DOC17/291337-2
SSD 5144 MOD 5

Mandalong Southern Extension Project - Modification 5 (SSD 5144 MOD 5)

ATTACHMENT A: OEH REVIEW OF THE STATEMENT OF ENVIRONMENTAL EFFECTS - PROPOSED MODIFICATION 5 OF THE MANDALONG SOUTHERN EXTENSION PROJECT (SSD 5144 MOD 5)

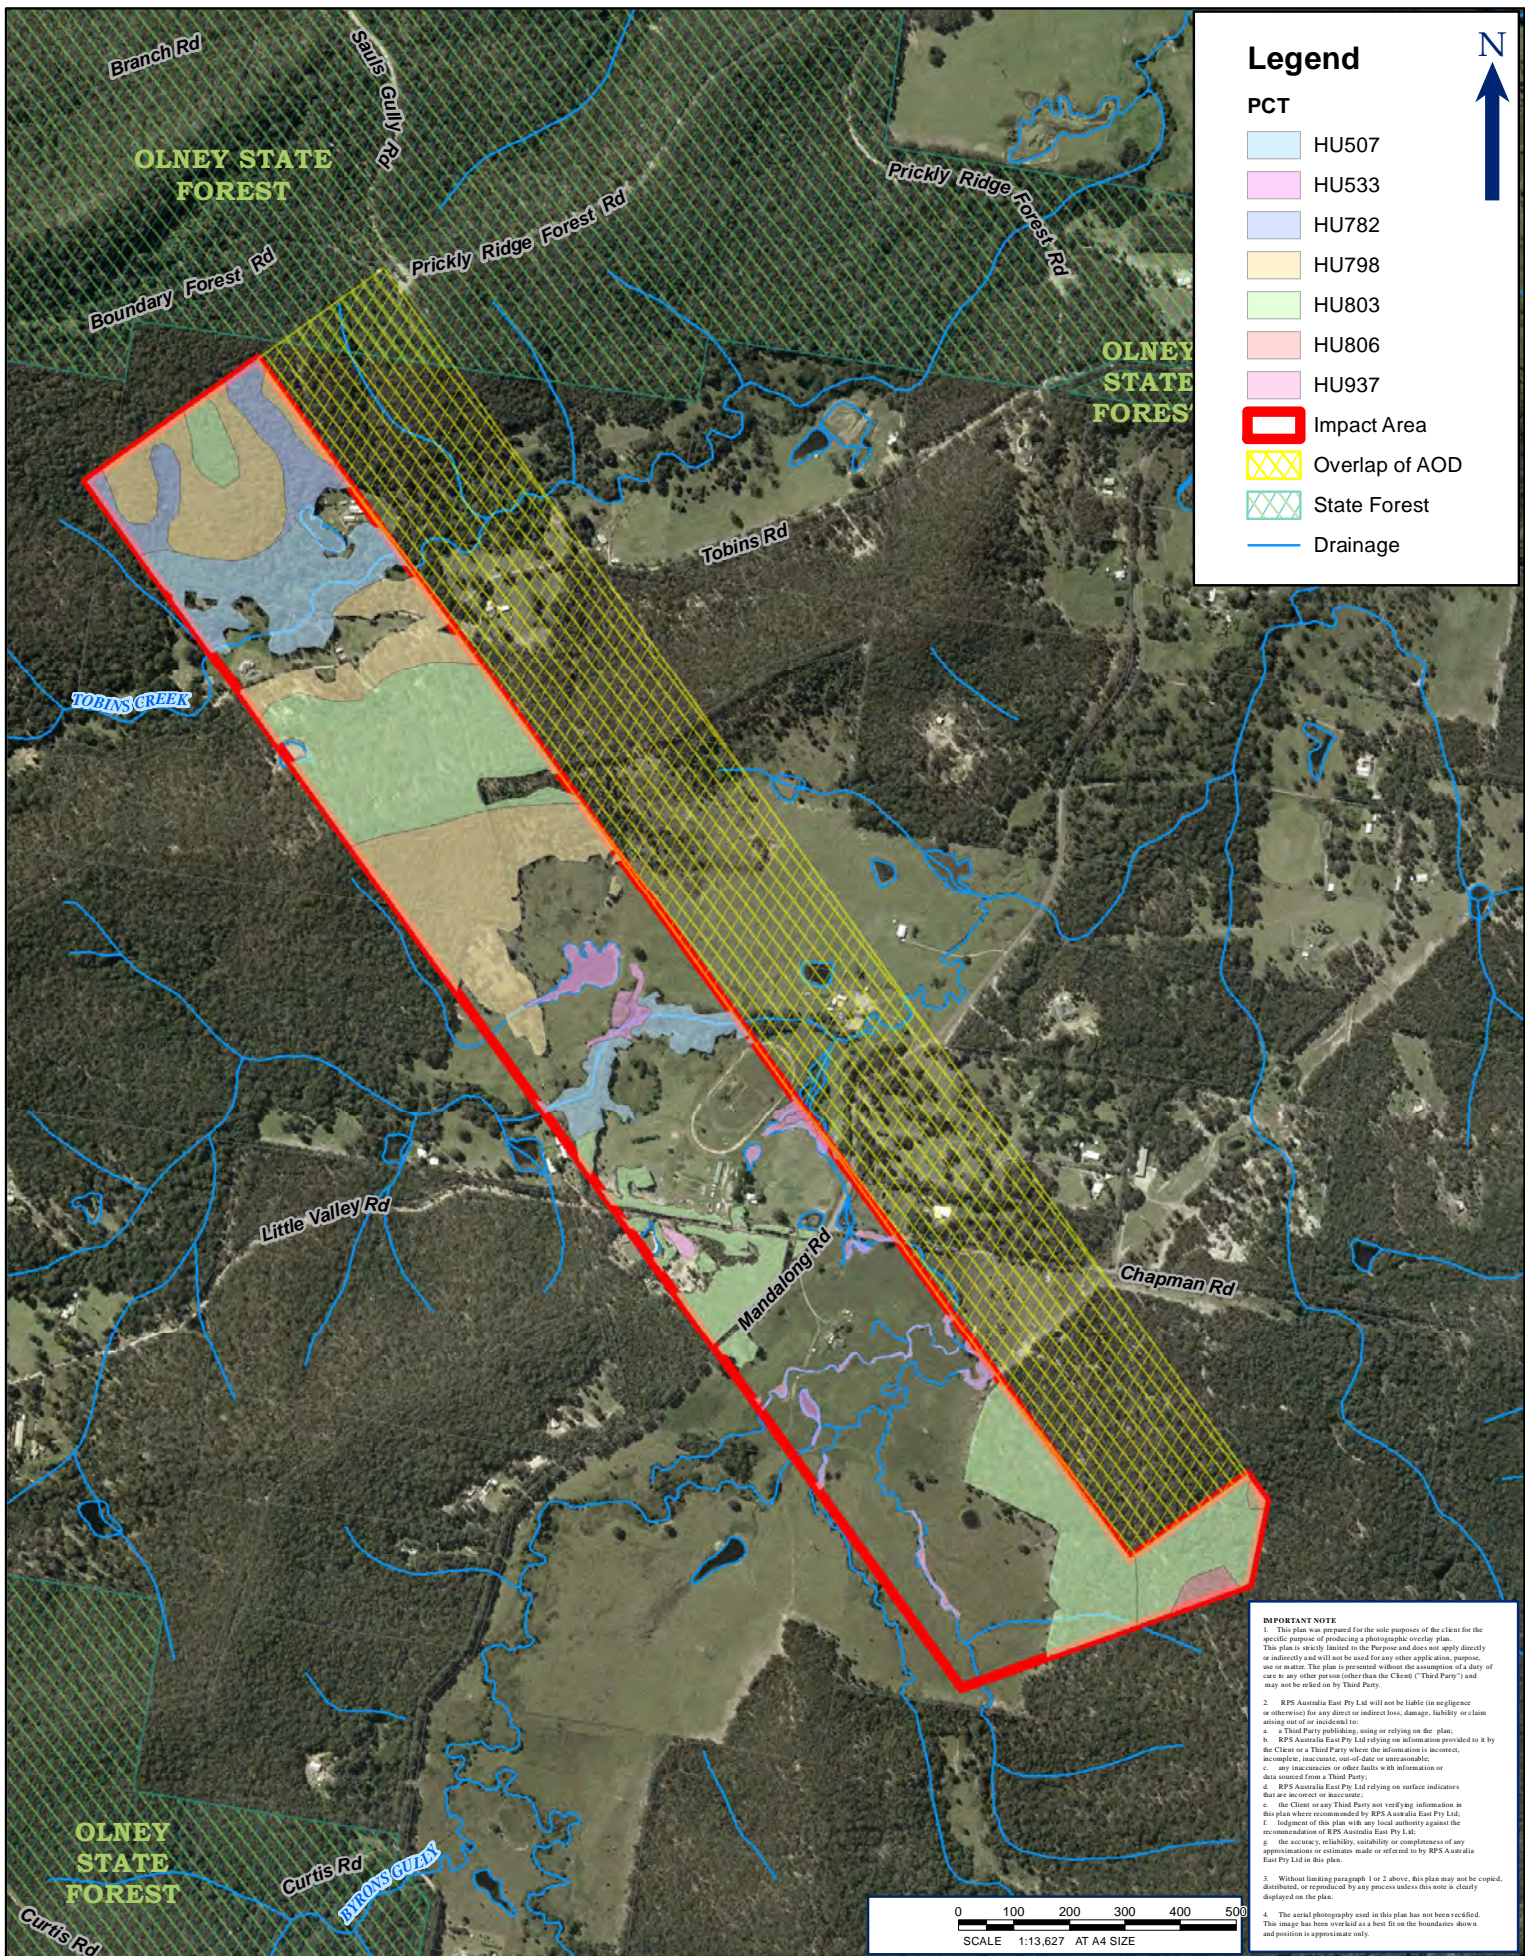
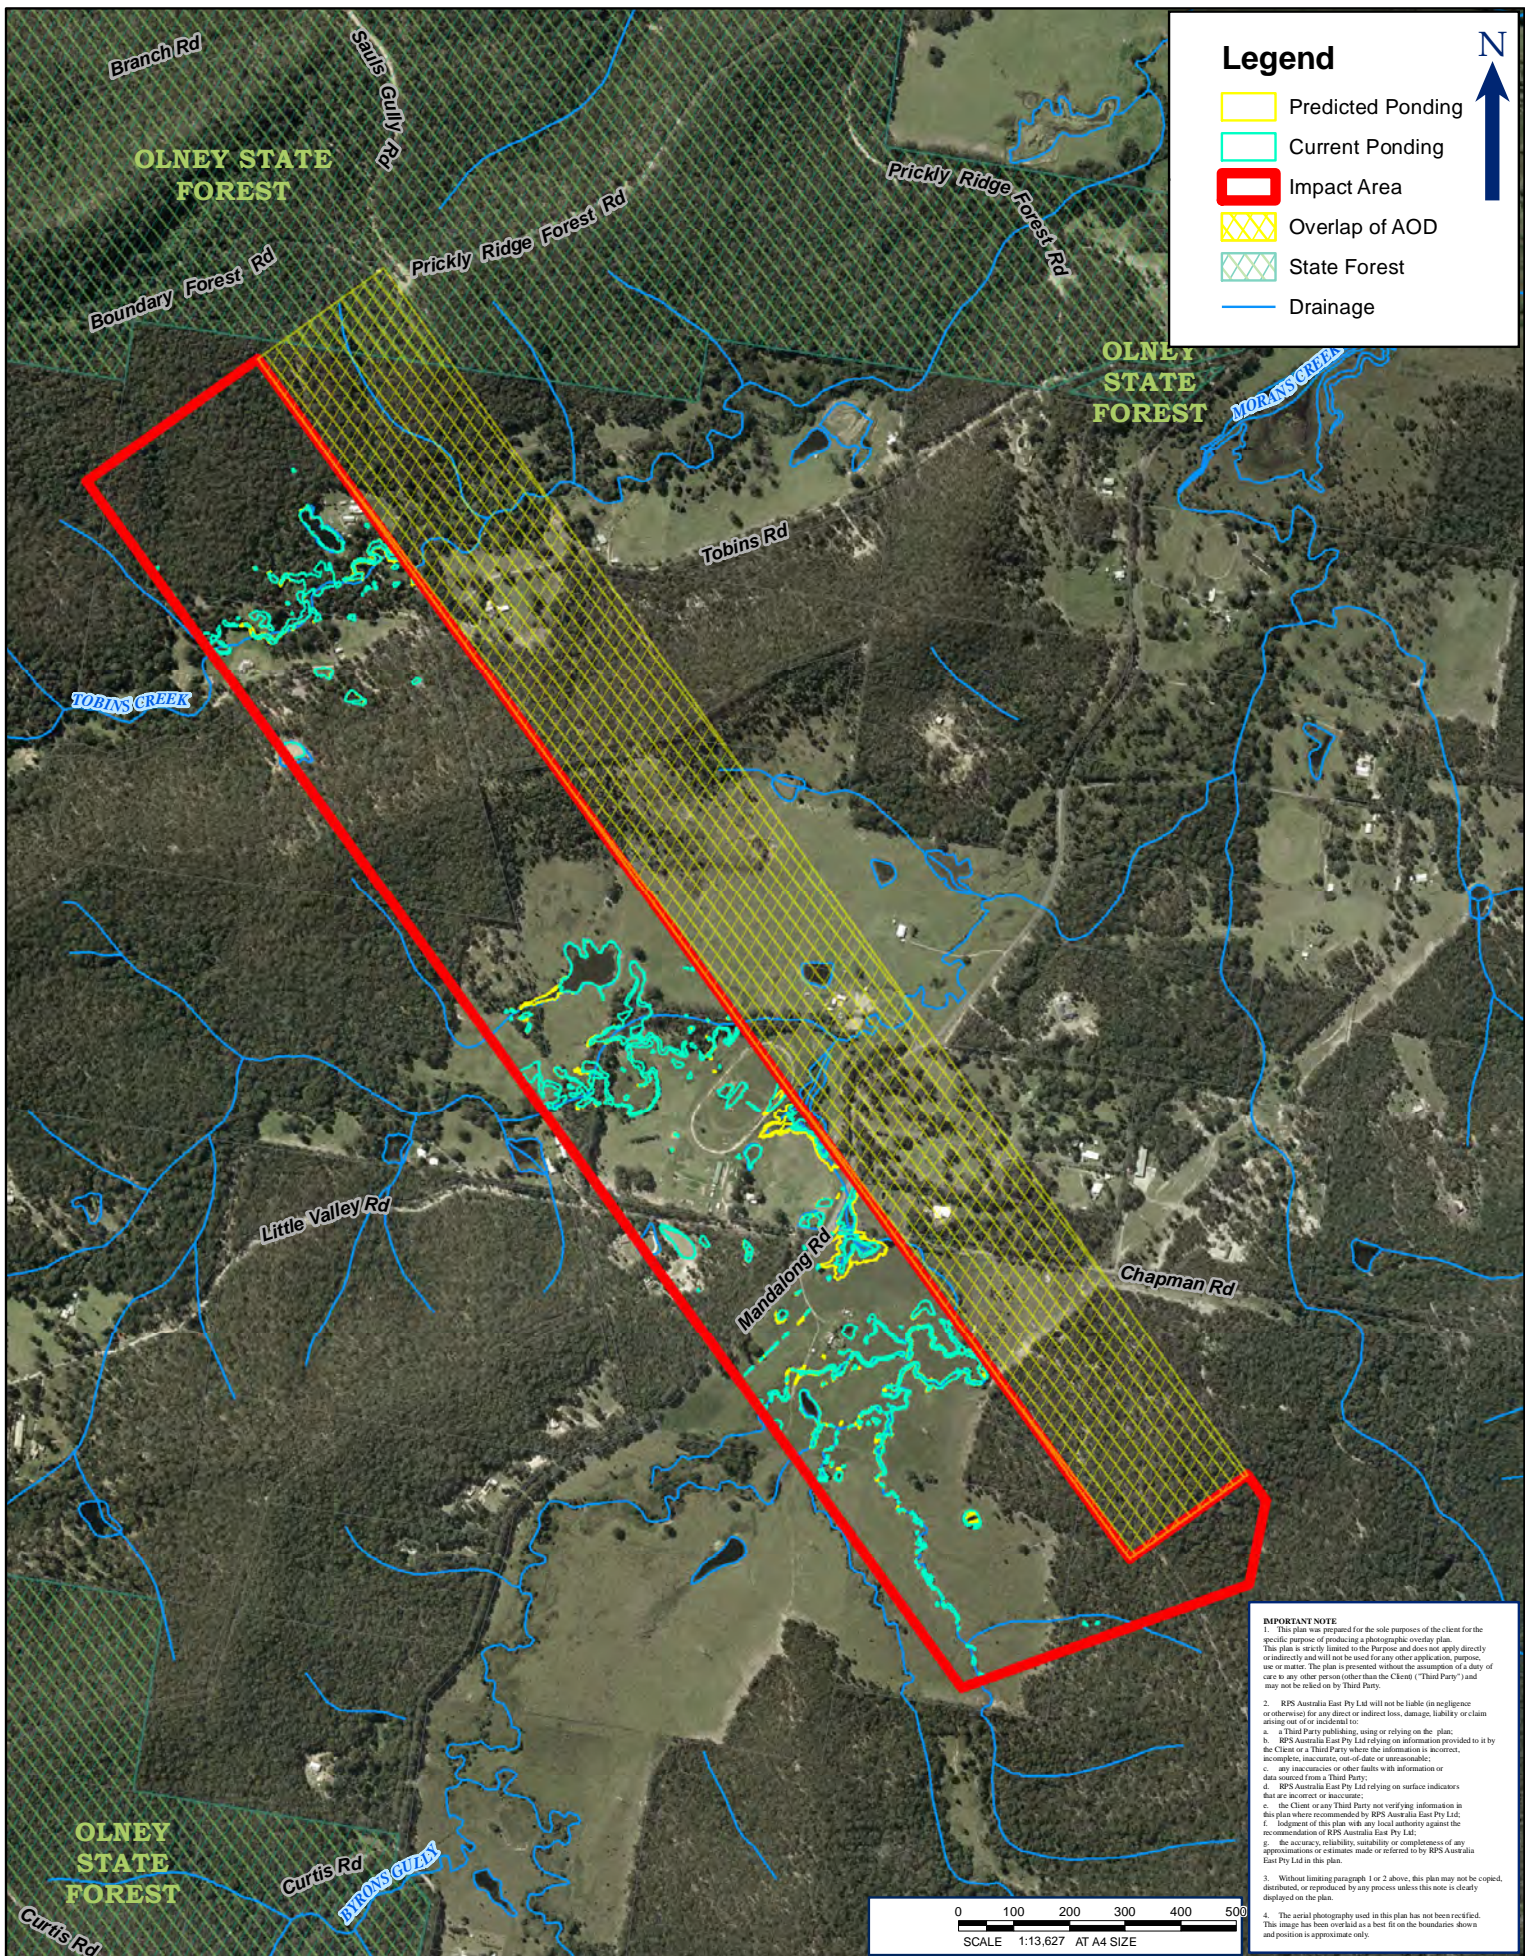
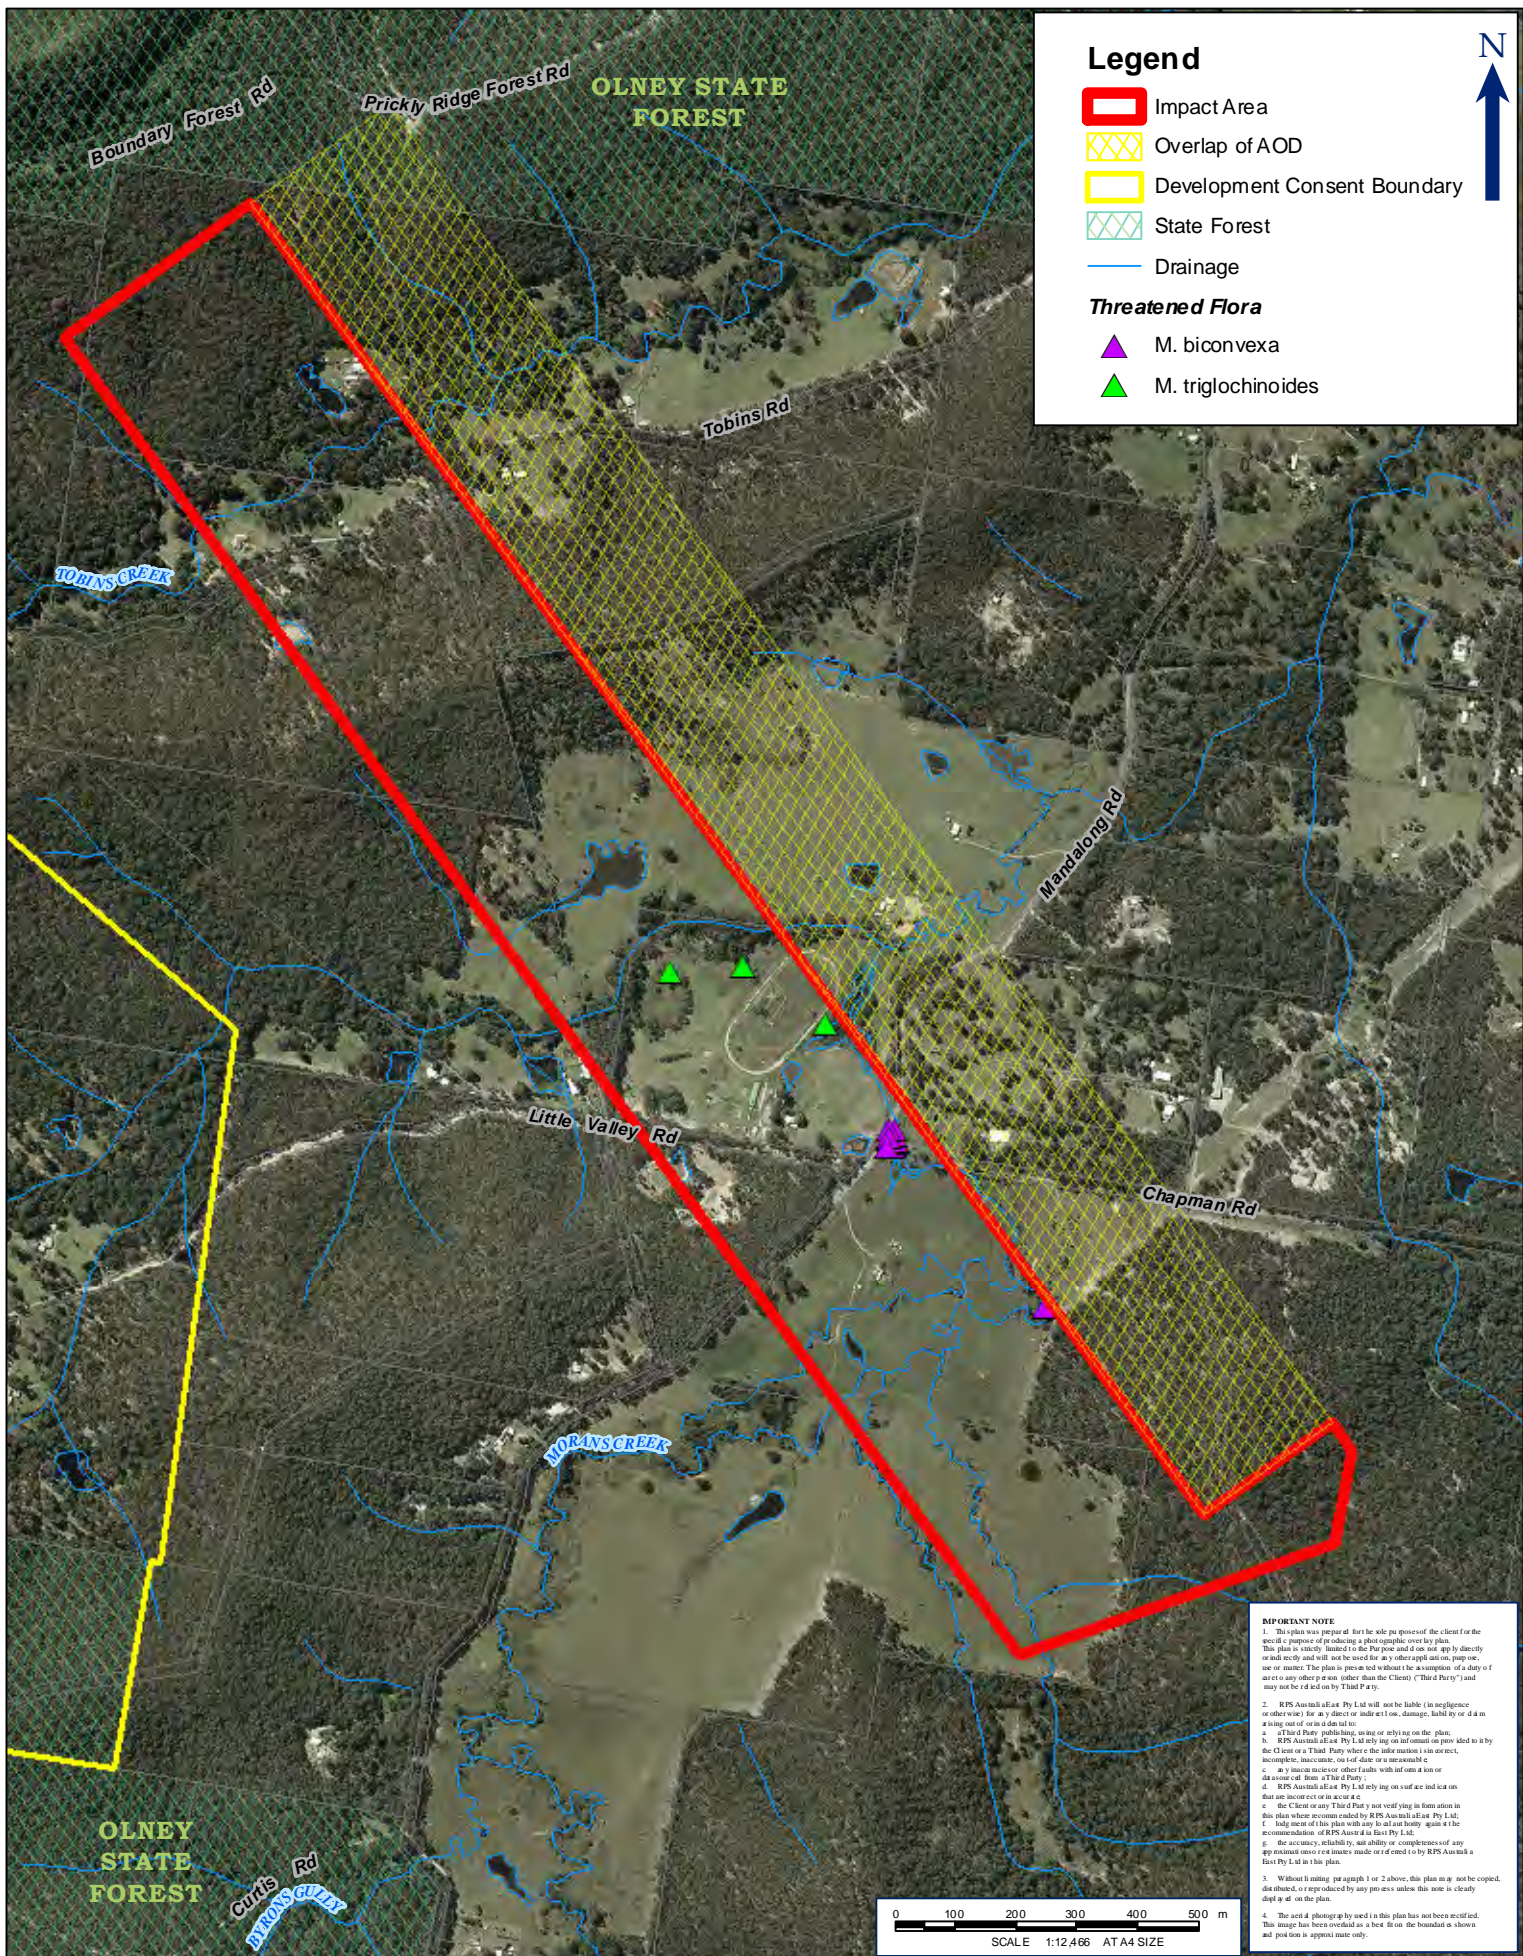
As a minor point, OEH notes that the 'Impact Area' (outlined in red in Figure 1 to 5 inclusive) considered in this assessment does not appear to include the proposed extension of longwall panel 24. Ecological and ponding data is provided for that extension area, and given it is within the Study Area it has been included in the FBA assessment.
